Appeal Decision

Appeal Ref: APP/R5510/D/21/3275441

22 Cleveland Road, UXBRIDGE, UB8 2DR

- The appeal is made under section 78 of the Town and Country Planning Act 1990 against a refusal to grant planning permission.
 - The appeal is made by Ms Rajini Shureshkumar against the decision of London Borough of Hillingdon.
 - The application Ref 64779/APP/2021/1080, dated 18 March 2021, was refused by notice dated 29 April 2021.
 - The development proposed is First Floor Side Extension.
-

PROPOSED FRONT ELEVATION

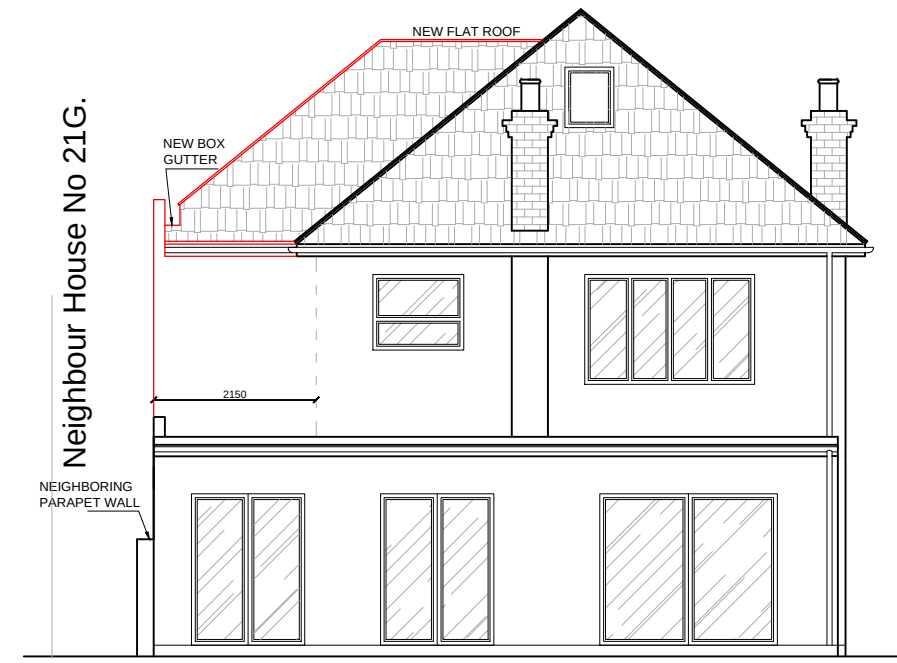
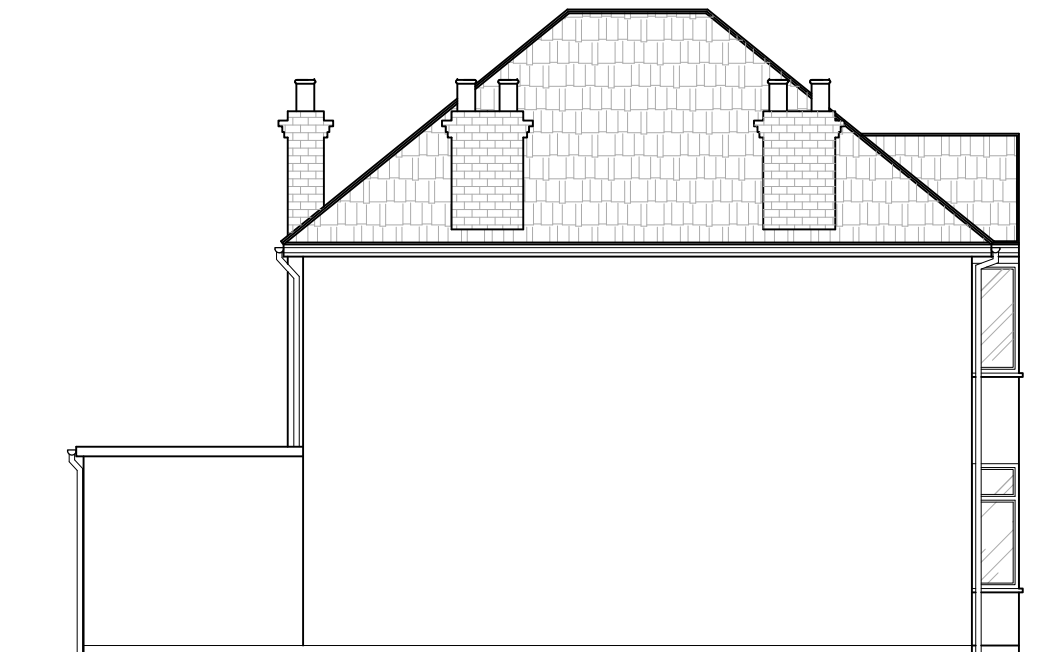
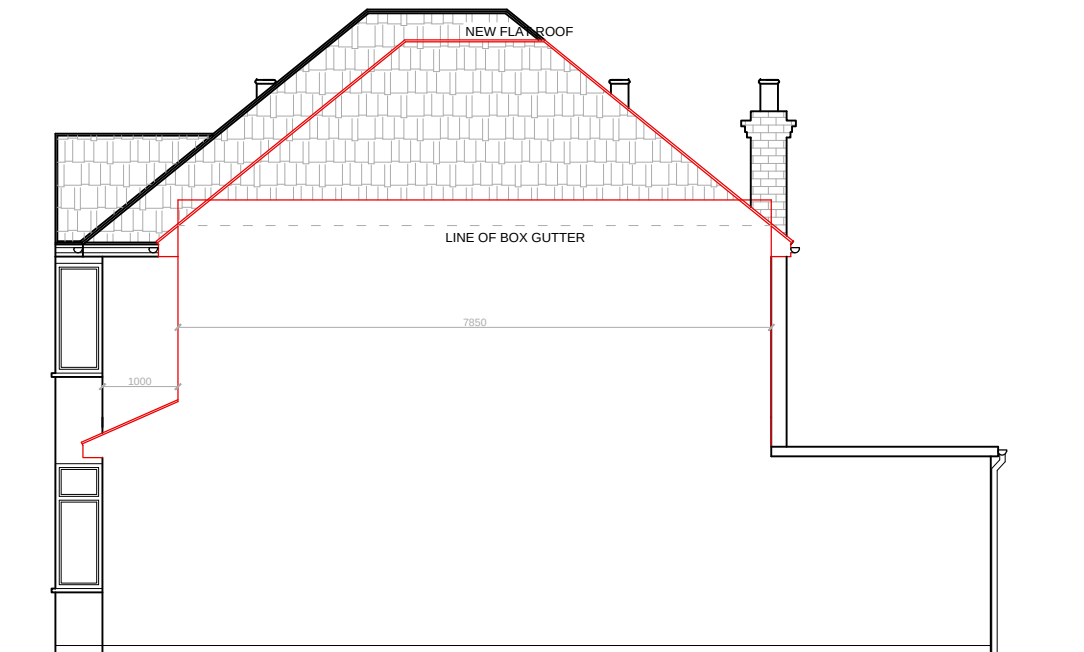
4. The proposal would see the erection of a second storey extension over the existing recently constructed single storey side extension. Set back from the front building line, the extension would incorporate a hipped roof to match the style of the roof to the original house. However, in so doing, the extension would unacceptably close the gap that exists with the modern house immediately to the north.

6. Whilst efforts have been made to respect the architectural detailing of the host property, I find that the proposal would have an undesirable terracing effect, which would have a negative visual impact on the character and appearance of

the appeal property and the area more generally. I am also conscious of the undesirable precedent that would arise should this appeal be allowed. The street scene presently benefits enormously from the fact that none of the properties that lay to the south have been extended at second floor. The pleasant Edwardian style and plot arrangement of this inter-war housing has so far been maintained and its distinctive characterful appearance retained as a consequence.

7. The appeal proposal would have a harmful effect on the character and appearance of the host property, which in turn would have an unacceptable and deleterious effect on the character and appearance of the area. Accordingly, the proposal would be contrary to the Council's policies in this regard as explained above.
